DOC21/1057302

1 December 2021

**Sydney Metro West – The Bays to Sydney CBD (SSI 19238057)
Advice on Environmental Impact Statement (EIS)**

1 Harwood Place, Sydney - Saturday, 27 June 2015

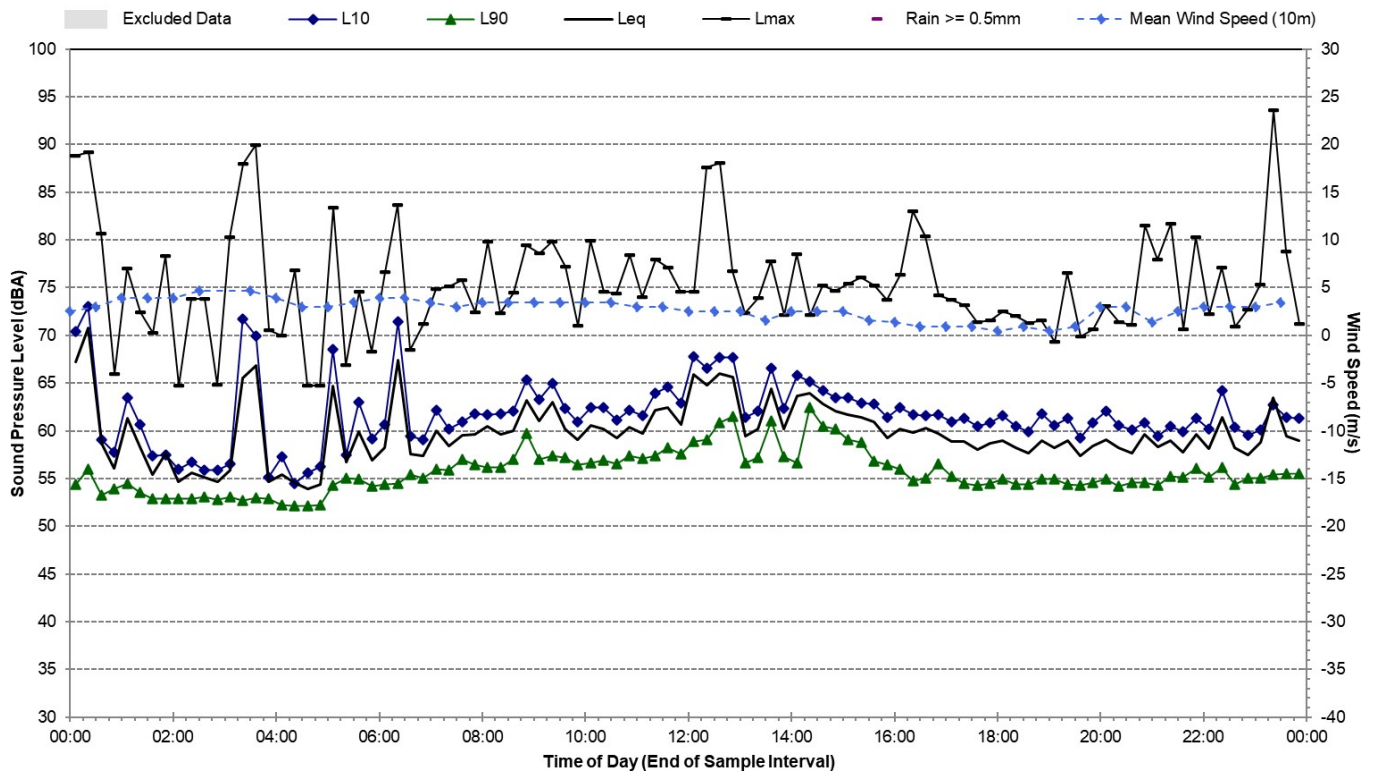
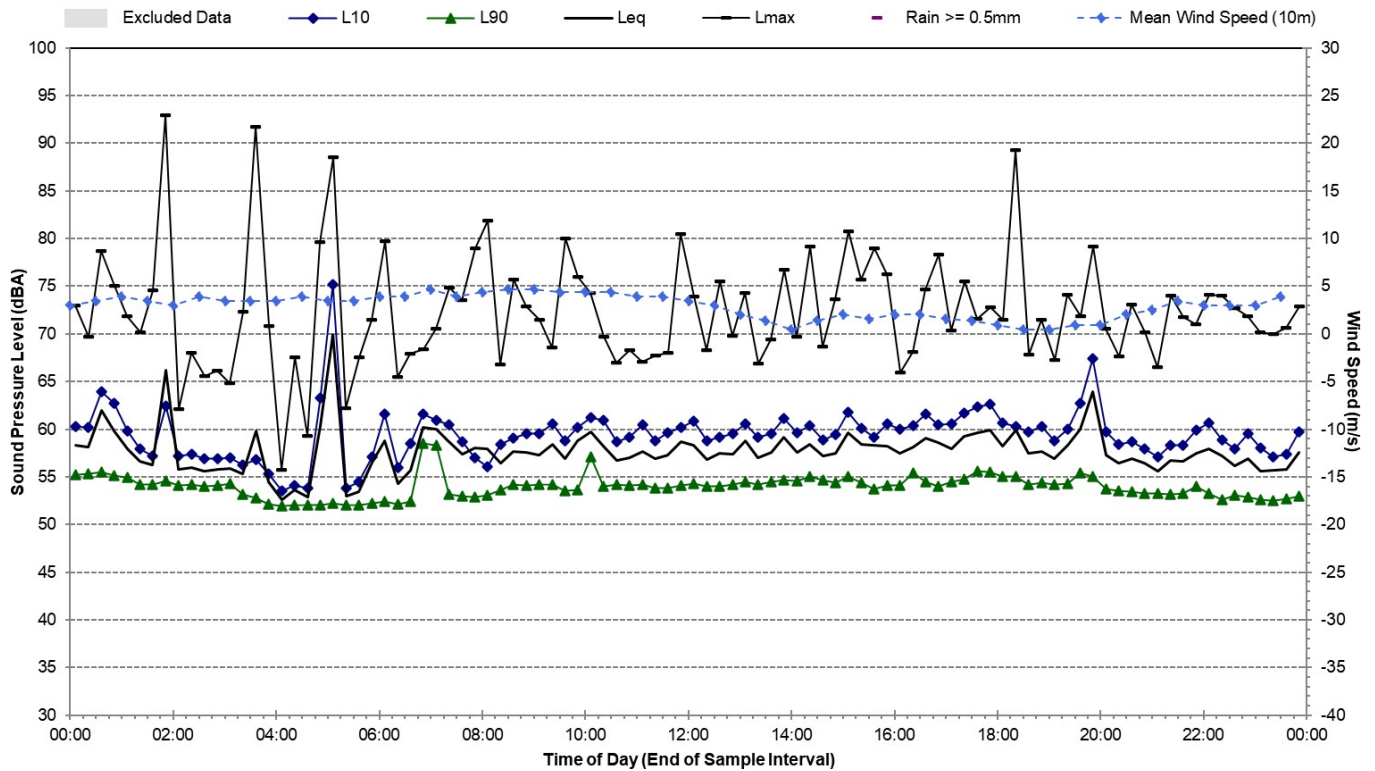
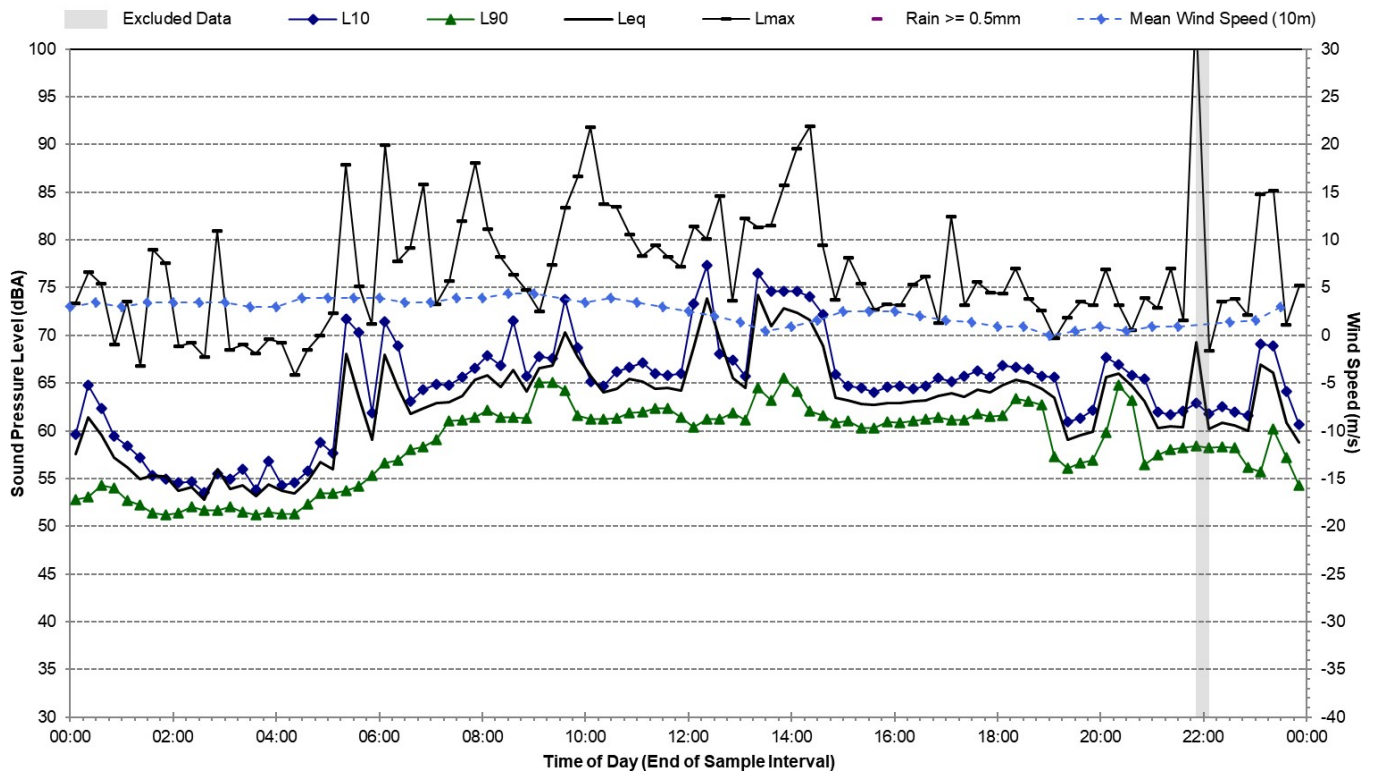
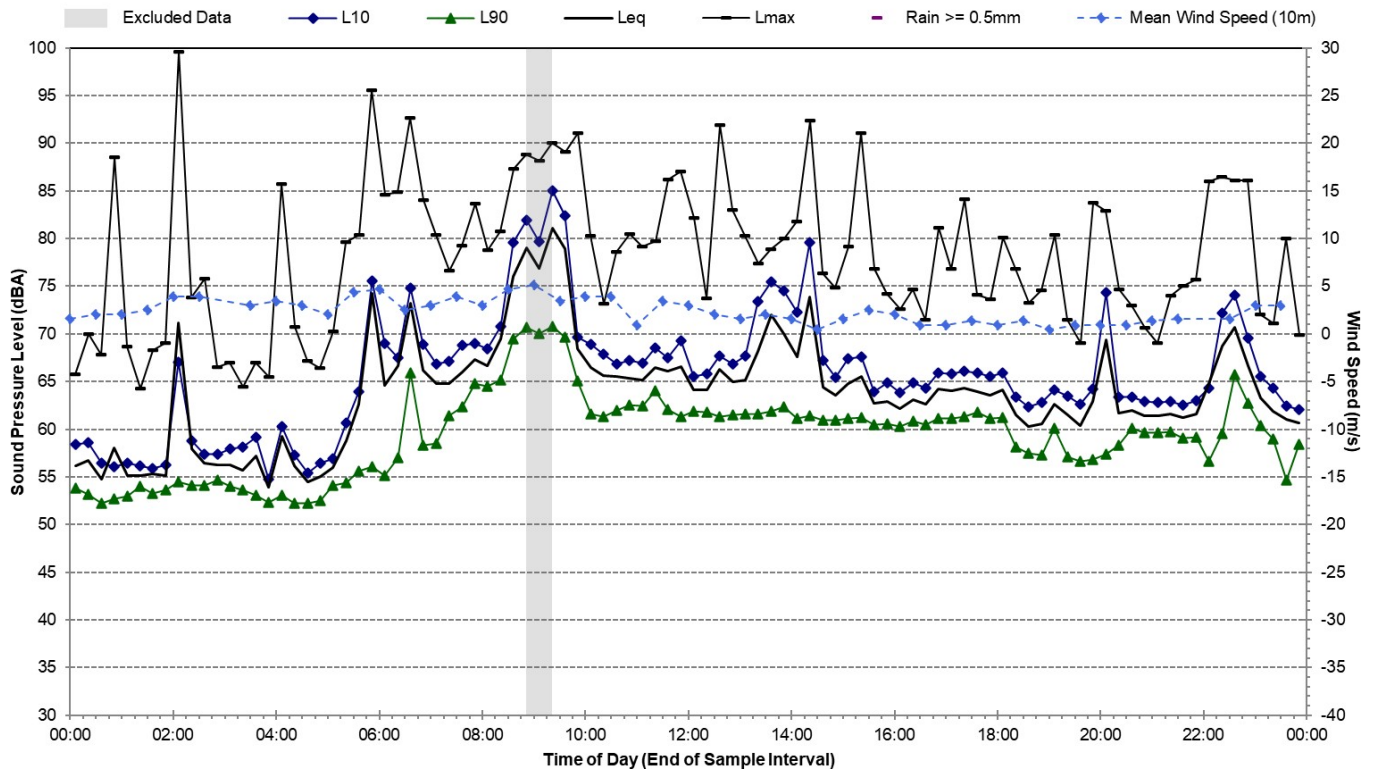
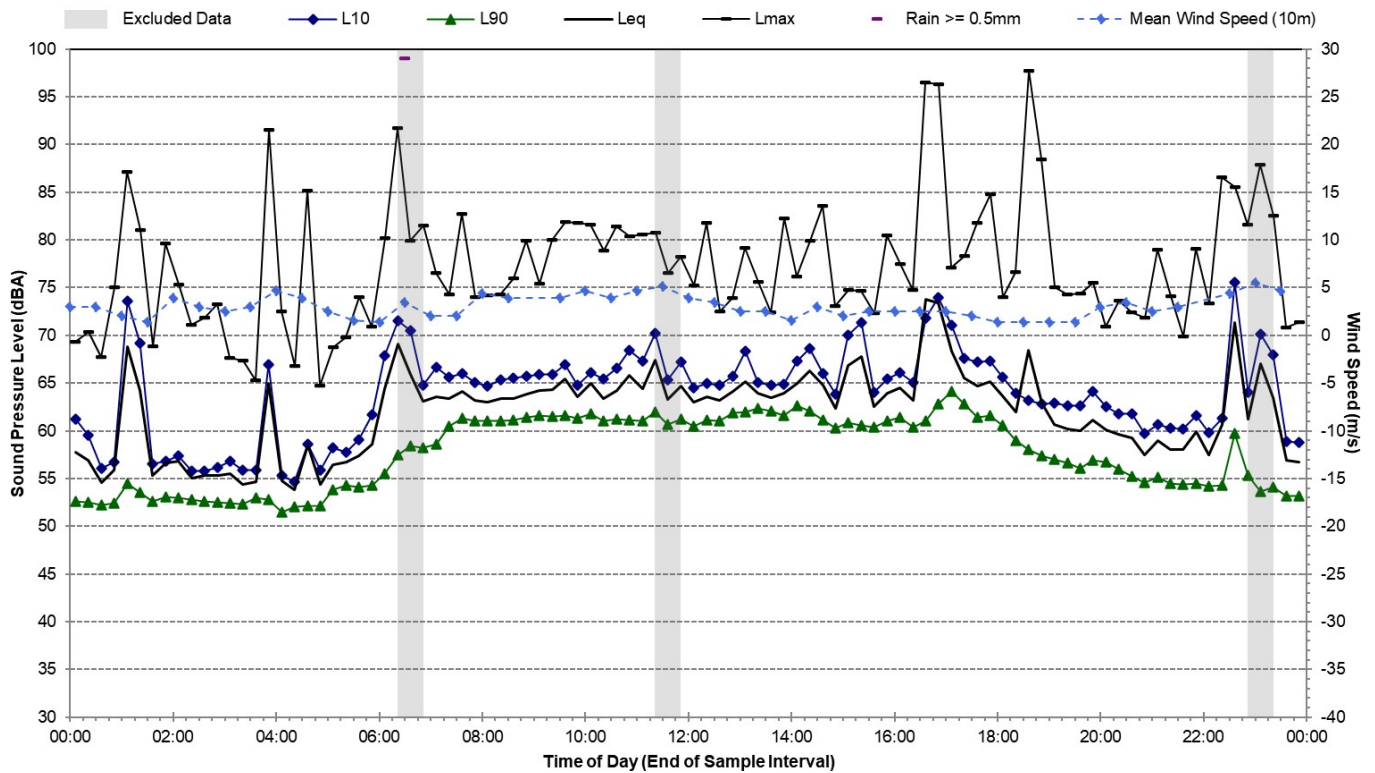
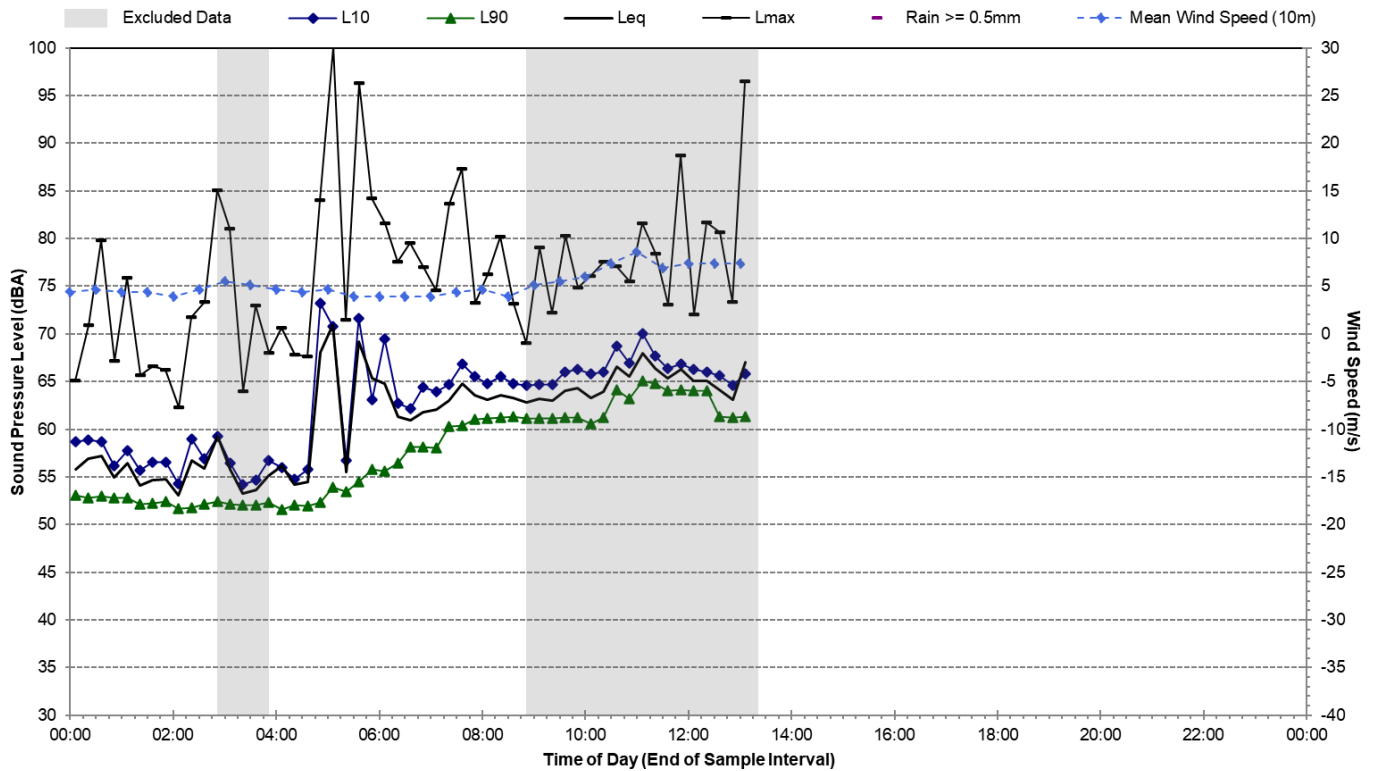
- The monitoring at Location B.06 was noted in Appendix B of the NVIA to have its background noise level affected by nearby mechanical plant.

The EPA recommends that the proponent clarifies to what extent this mechanical plant affected the measurements and whether the noise monitoring data at Location B.06 is representative of background levels in the NCA.

- Furthermore, it appears that the monitoring equipment at Location B.06 was located on a balcony and there is potential for it to be affected by façade reflections. Since RBLs are a free-field noise level, any correction made for façade reflection should be stated in the NVIA.

The EPA recommends that the façade reflection status of all background noise measurements is included in the NVIA and any adjustments made to the measured noise levels reported and justified.

- The information supplied for monitoring Location B.06 is not consistent within the NVIA. Page 43 (of 70) of the NVIA Appendix B document gives the address as 1 Hosking Place and dates between 2 May 2019 and 20 May 2019, however the graphs that follow have dates in June 2015 and the address as 1 Harwood Place.

The EPA recommends that the proponent clarifies addresses and dates for all monitoring locations.

- Monitoring graphs in Appendix B of the NVIA appear to report the wind speed at 1.5 metres. The meteorological data for all locations appears to have been sourced from the Bureau of Meteorology station at Observatory Hill. It is not clear how wind speeds were converted from the height of station to 1.5 metres and also how the wind speed was calculated at the monitoring location on the balcony at Location B.06.

The EPA recommends that the NVIA includes the method and assumptions used to convert wind speeds to 1.5 metres, and the height of the microphones above 1.5 metres from ground level and a justification it is appropriate.
